Surface water drainage;

APPLICATION NO: AL/28/20/DOC

Site Address: Land To South Of Barnside Hook Lane Aldingbourne PO20 3TE

Description of Works: Approval of details reserved by condition imposed under ref APP/C3810/W/16/3155330 (AL/8/16/OUT) relating to Condition Nos 11 - visibility splay, 12 - fire hydrant, 13 - foul drainage, 14 - surface water drainage and 18 - external lighting

P4	11.09.19	AMENDED TO SUIT WSSC COMMENTS.	PJM
P3	15.07.19	NOTE TO TELEPHONE POLE ADDED.	JMB
P2	01.07.19	EXTENT OF WORKS AMENDED.	JMB
P1	14.06.19	PRELIMINARY ISSUE FOR COMMENT	JMB
Revision	Date	Description	By

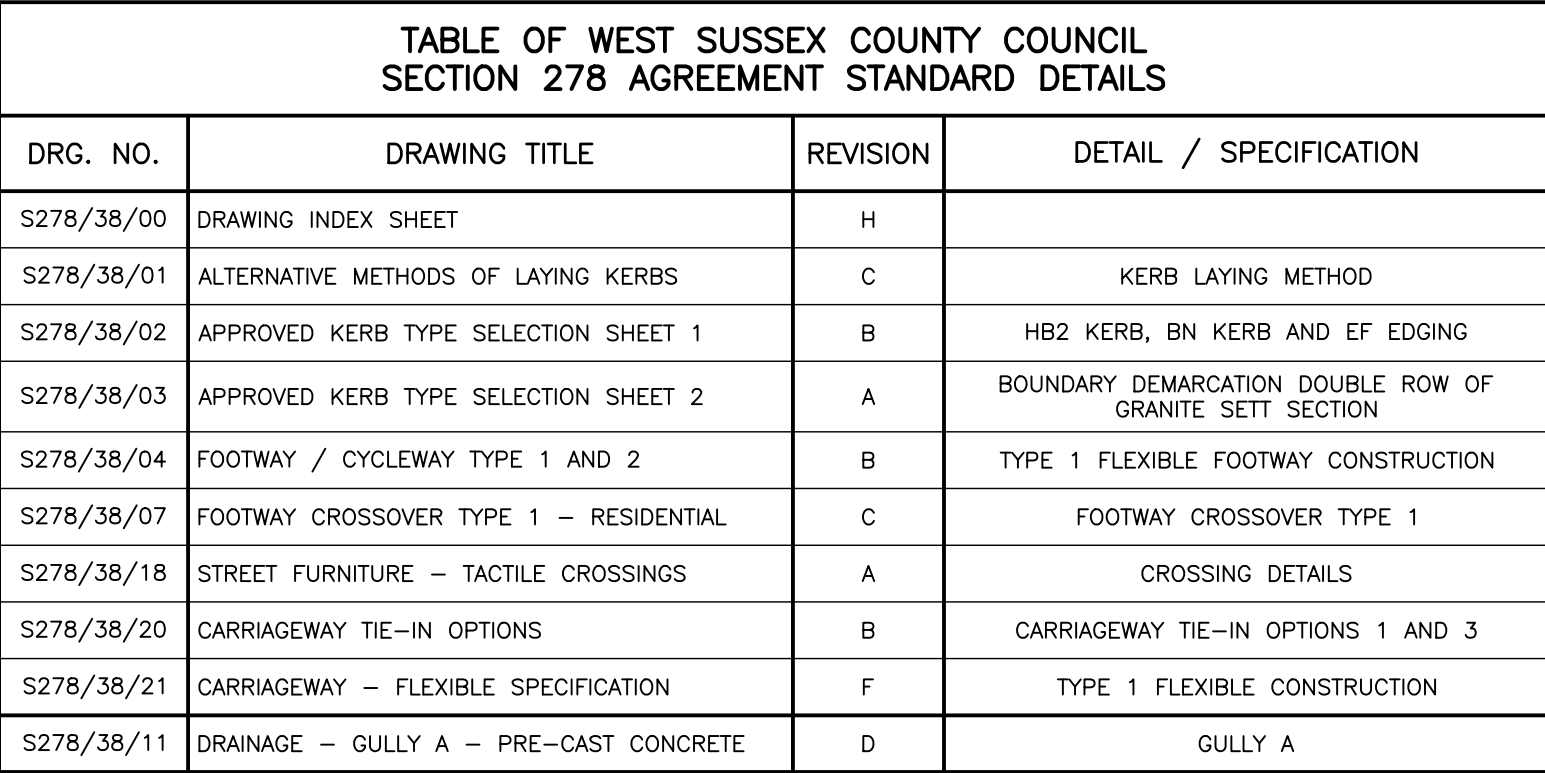
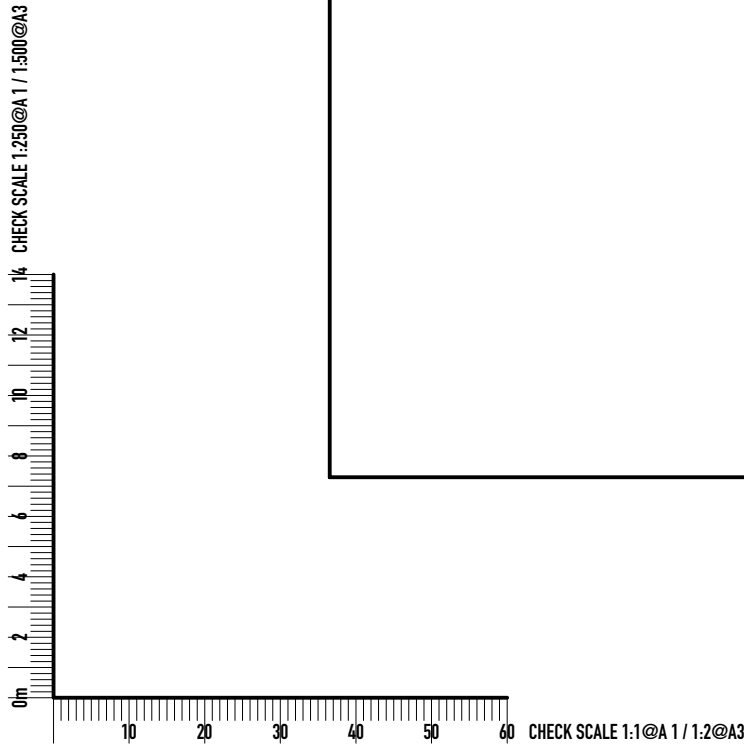
3. Provide hydraulic flow calculations.
4. SA10 is very close to the pond bank and could cause stability issues. Please advise.
5. Pipes not connecting to manholes to connect via oblique 45 degree junctions.

6. Indicate manhole invert levels at all manholes/rodding eyes/tanks (outlets) & headwalls (inlets/outlets).
7. Provide pipe diameters on pond outlet.
8. Provide manufacturers technical details of hydrobrake/discharge rate.

9. Silt traps (catchpit manholes) to be provided immediately upstream of all soakaways.
10. ACO drain rear of plot 2 is connecting against the flow.
11. What work has been carried out to the existing pond in terms of maintenance? Ordnance survey showed an existing outlet on the south side of the pond – what has happened to this?

13. There appears to be no permeable paving to improve water quality just a petrol interceptor. Was this agreed? – provide evidence.
14. Ponds inlet at S2 – 90 degree pipe configuration – pipe angle should be increased to provide better flow arrangement.
